Ribble Valley Borough Council
By email

Your ref: 3/2022/0199
Our ref: DC/22/1047
Date: 12-APR-22

Location: Hillside, West Bradford Road, Clitheroe BB7 4QD

Proposal: The application is to extend the residential curtilage of the rear garden and enclose the new boundary

PROJECT
EXTENSION OF LAND TO GARDEN
PLAN AS PROPOSED
SCALE 1:100
CLIENT MR C RYLE
02/12/2021

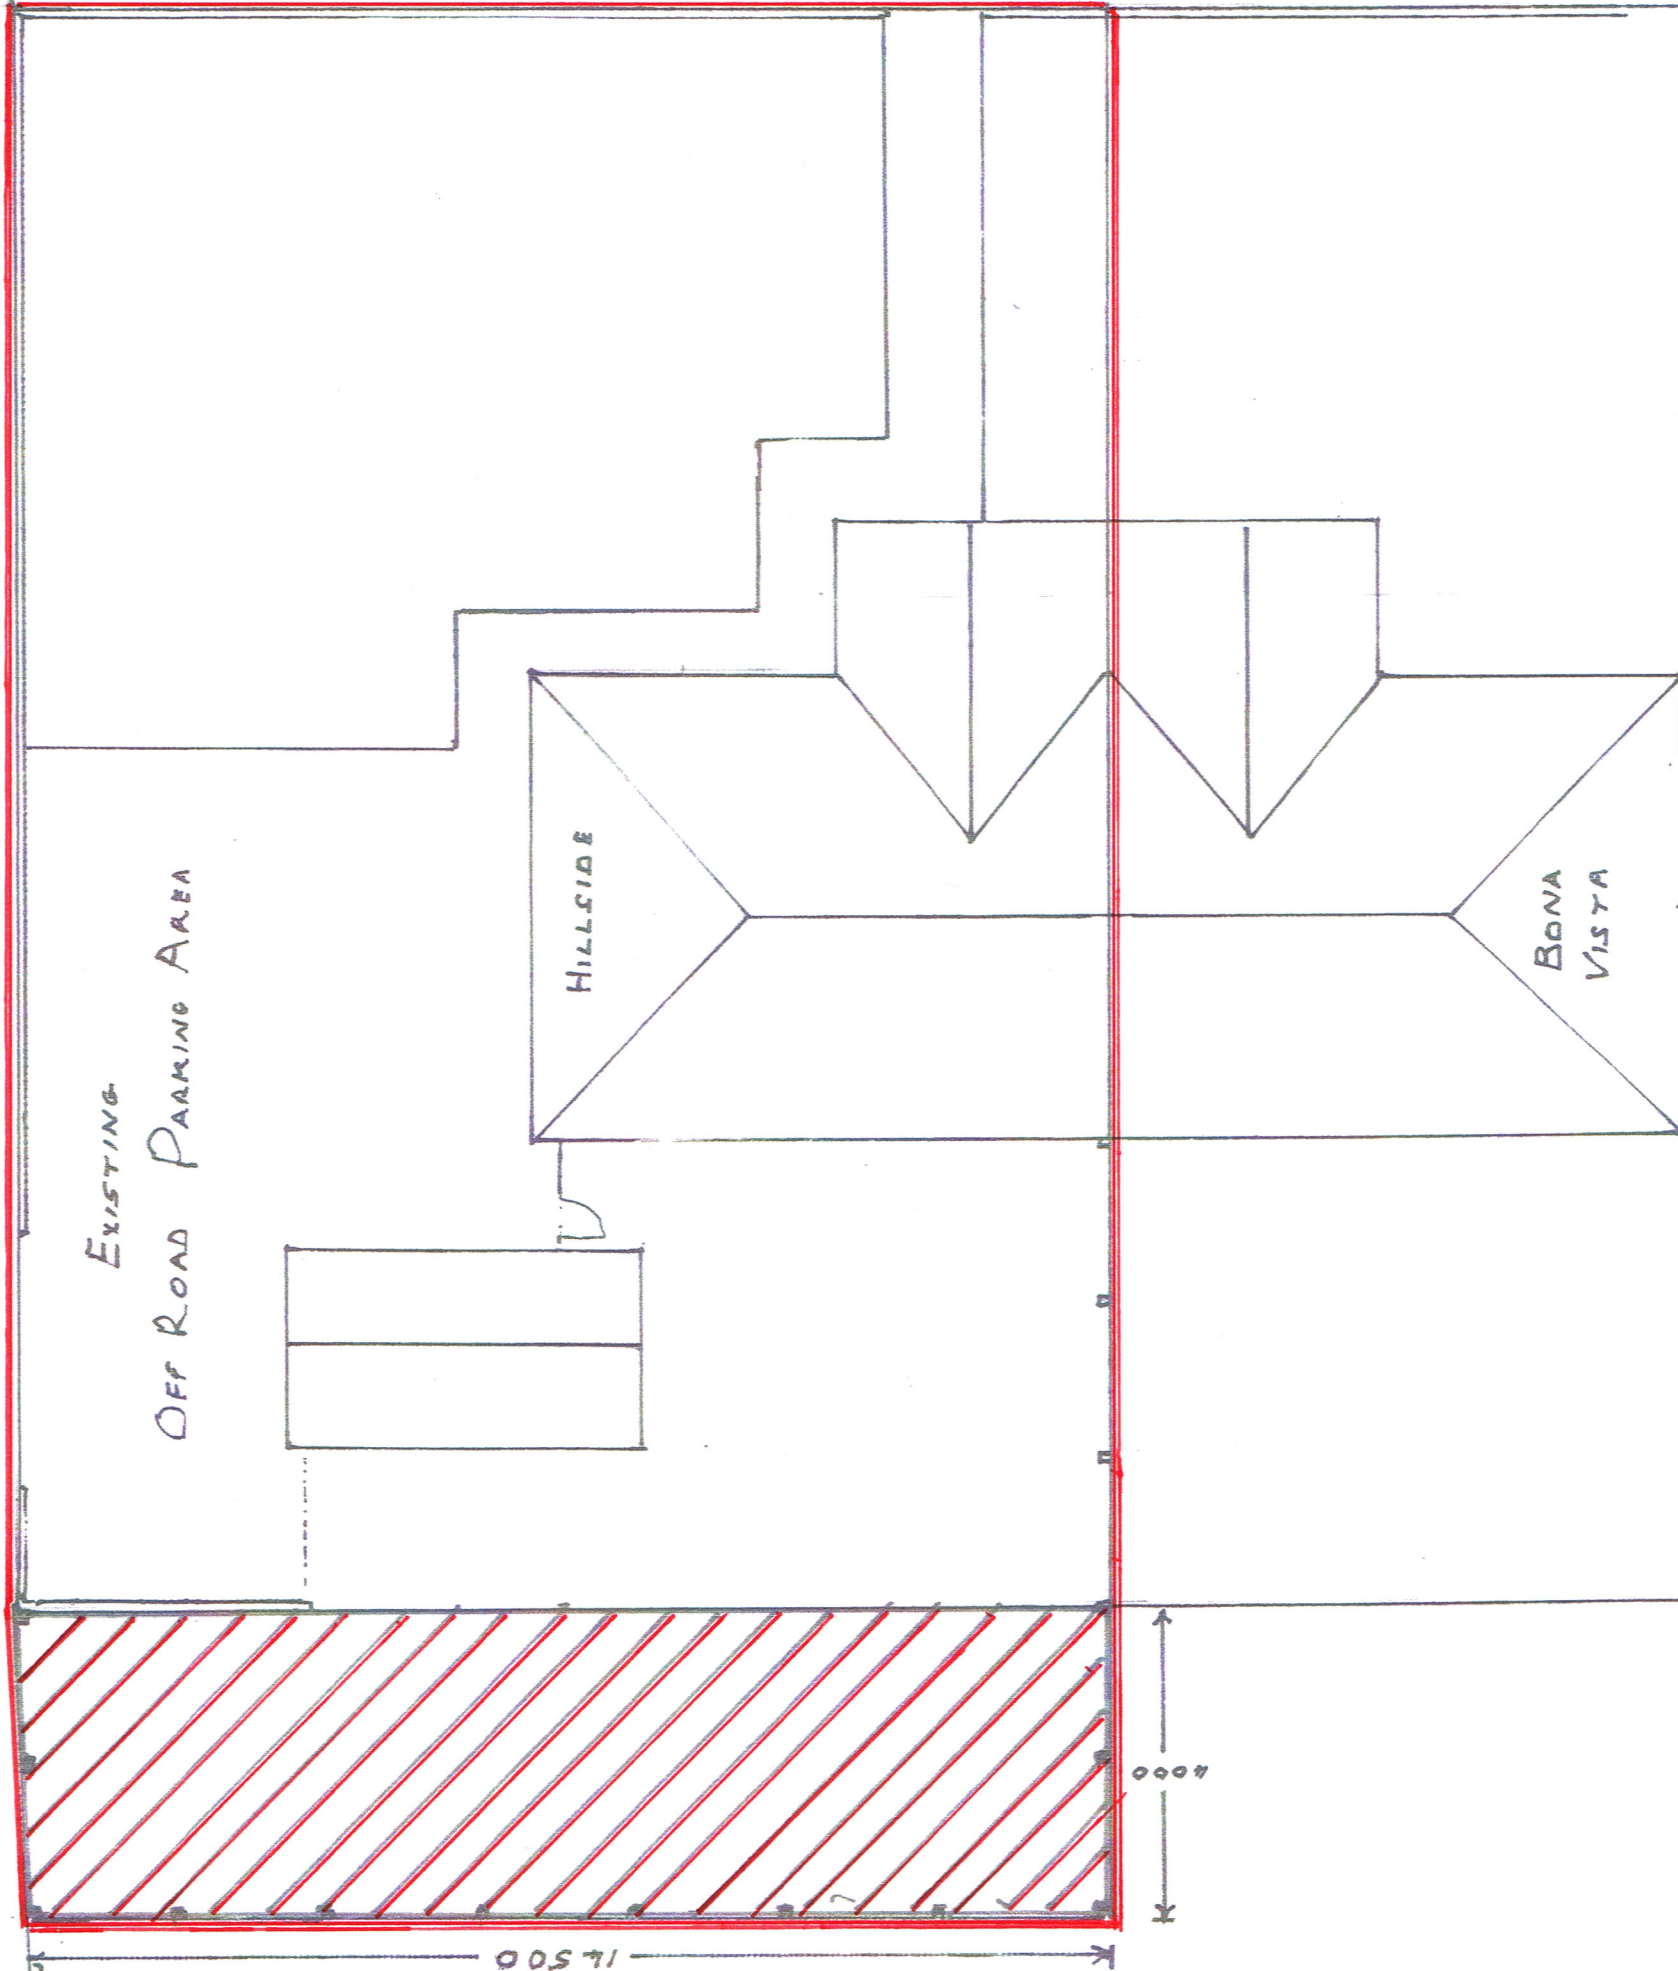
Following our review of the proposed site layout, we can confirm that the proposal is not acceptable to United Utilities as proposed features appear to be located above our rising main (a public sewer operating at high pressure). Until such time as the applicant has resolved all concerns regarding the proximity of proposed development to our asset(s), our position is that we must OBJECT to the proposal. The applicant should contact our Wastewater Developer Services team to discuss (wastewaterdeveloperservices@uuplc.co.uk) at their earliest convenience.

Following our review of the proposed site layout, we can confirm that the proposal is not acceptable to United Utilities as proposed features appear to be located above our rising main. Until such time as the applicant has resolved all concerns regarding the proximity of proposed

development to our asset(s), our position is that we must OBJECT to the proposal. The applicant should contact our Developer Services team to discuss.

A rising main (a public sewer operating at high pressure) crosses this site and it must not be built over. We require an access strip for maintenance or replacement and this access must not be compromised in any way. The applicant should determine the precise location, depth and condition of the pipeline as this can influence the required stand-off distance from any structure. Further advice is available from our Developer Services team. See Contacts section below.
